12/17/03 met w/MSW in office & then owner & Contractor on site
Modifications to be made

CBU # 124-5-9
Permit # 03-1210

57 REVERE ST.

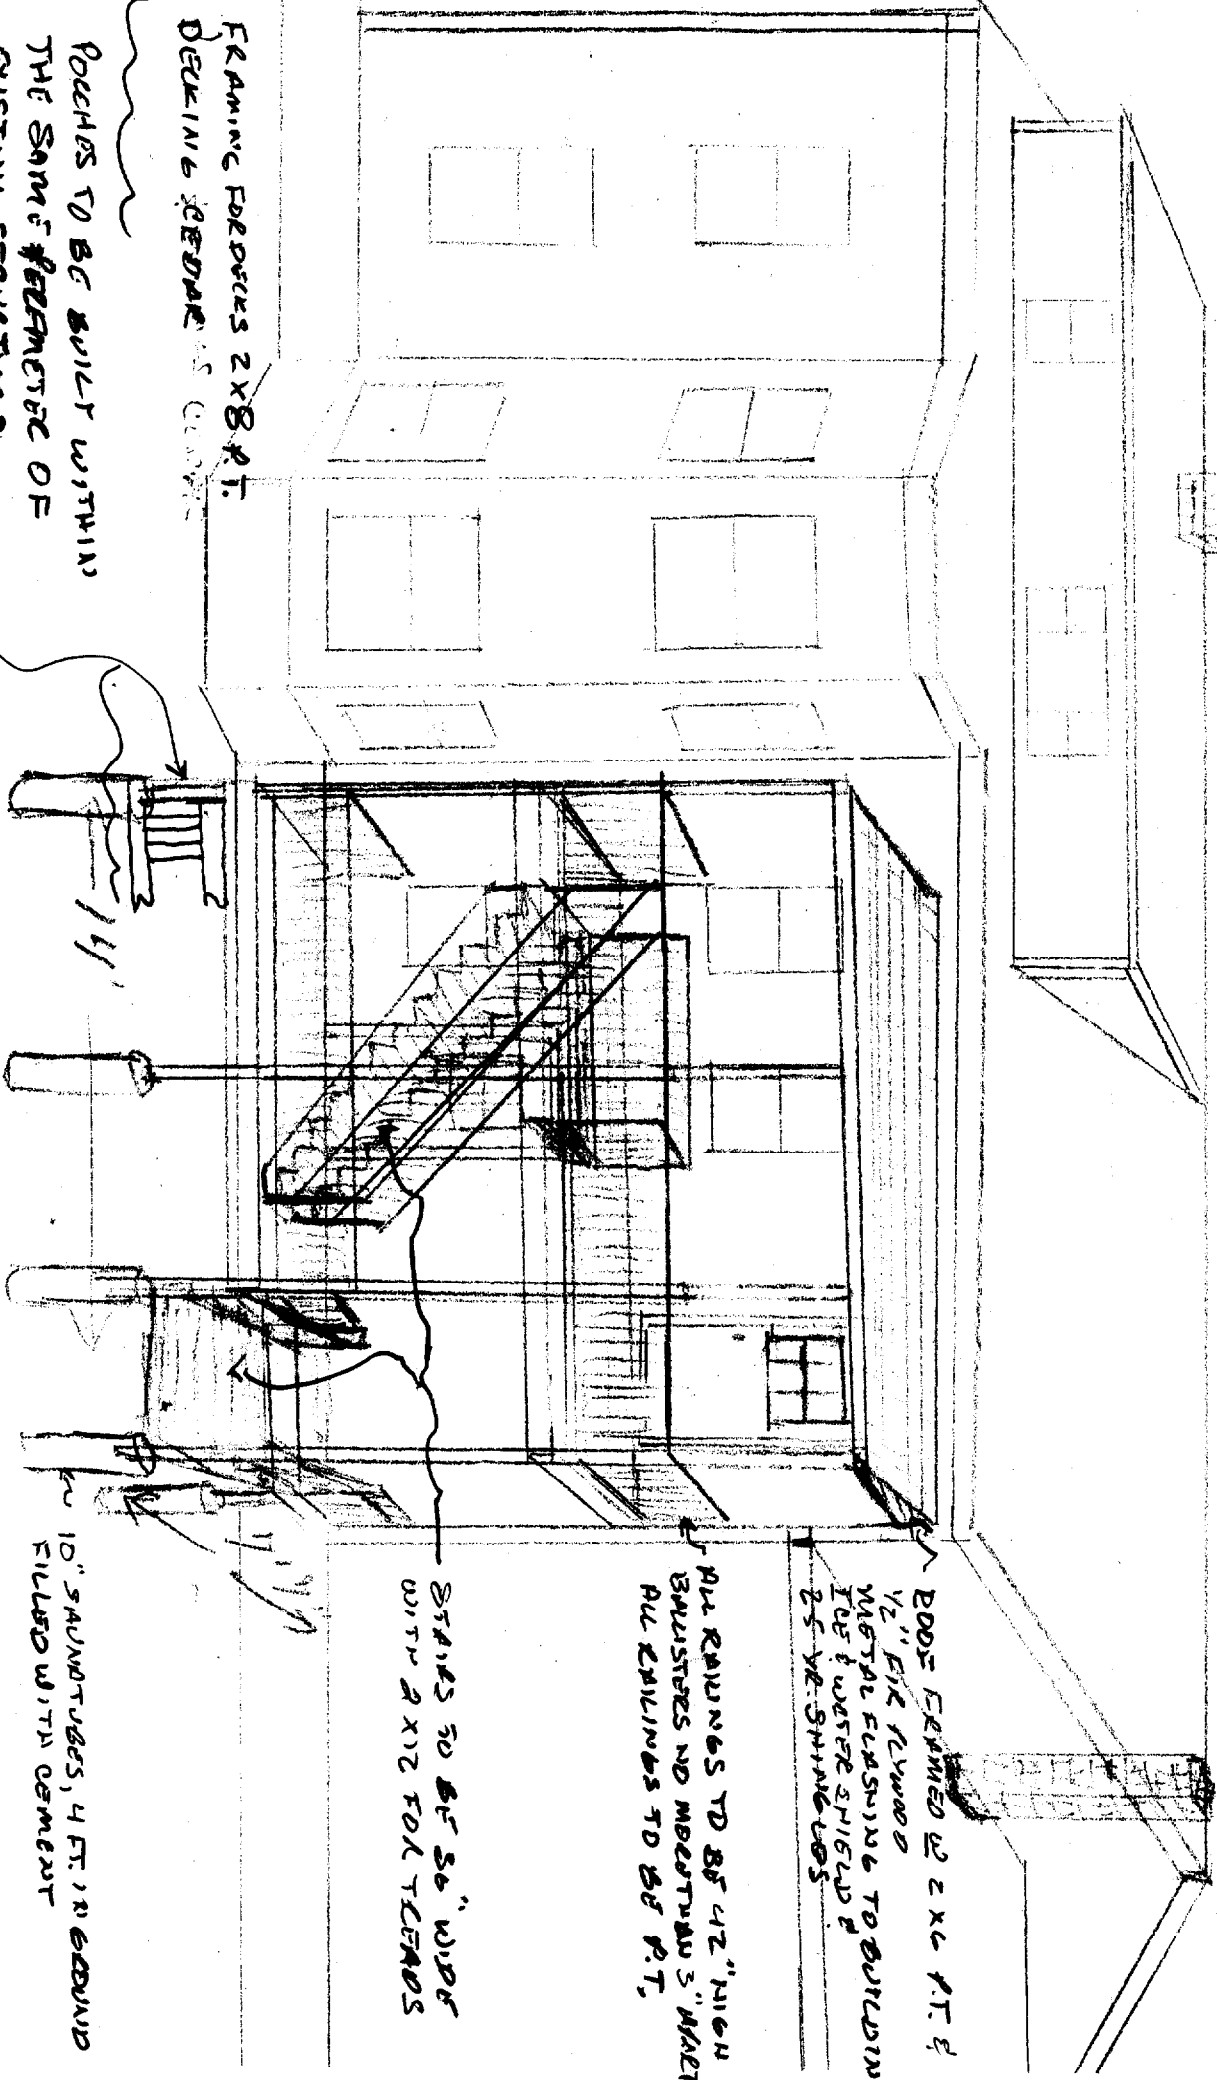
① stairs grade to 1st - Riser
Risers @ 7 1/2" s/B 7" Max
Treads @ 11 1/2" w 1/2" nosing = 11 net But should not have nosing

② steps 1st to landing
Risers 7 1/2" s/B MAX 7" s/B to 1 1/4"
TREAD @ 11 1/2" w 1 1/2" nose = 10 net - SB 11" w/NO NOSING
Guardrail Both Sides 1st to 2nd stair range 31" to 38" s/B 42"
Risers 1st to 2nd 7 1/2" s/B 7" MAX - ALSO - NO KICKBOARDS @ RISERS
TREADS 11 1/2" w 1/2" to 3/4" nosing = NET 10 3/4" to 11" s/B NET 11" w/NO NOSE
HAND RAIL HEIGHT 1st to 2nd 28" to 36"

Handrails 1022.2 34"-38"

③ steps 2nd to 3rd fl deck
Risers 8" & 8 1/4"
Tread 10 3/4" w 3/4" nosing

④ Existing Power vent Blows directly into exit path on 1st & 2nd
(OK per PFD & MSW - Existing)

- ① ALL HANDRAILS to be 34" - 38" measured at leading edge of treads
- ② Tread nosing w/ fl deck to landing to be consistent 3/4" to 1 1/4"
- ③ Guardrails to be raised to 42" both sides of stairs w/ fl deck to 2nd fl deck
- ④ Solid risers to be installed on stairs 1st to 2nd, MUST MAINTAIN uniform tread & nose dimensions
- ⑤ Steps for 2nd fl deck to apt Treads & Risers must be consistent height - 7 3/4" - 10" max

12/30/03 - checked treats & used SW/cover OK
Reul/Guard has OK - OK to close out permit
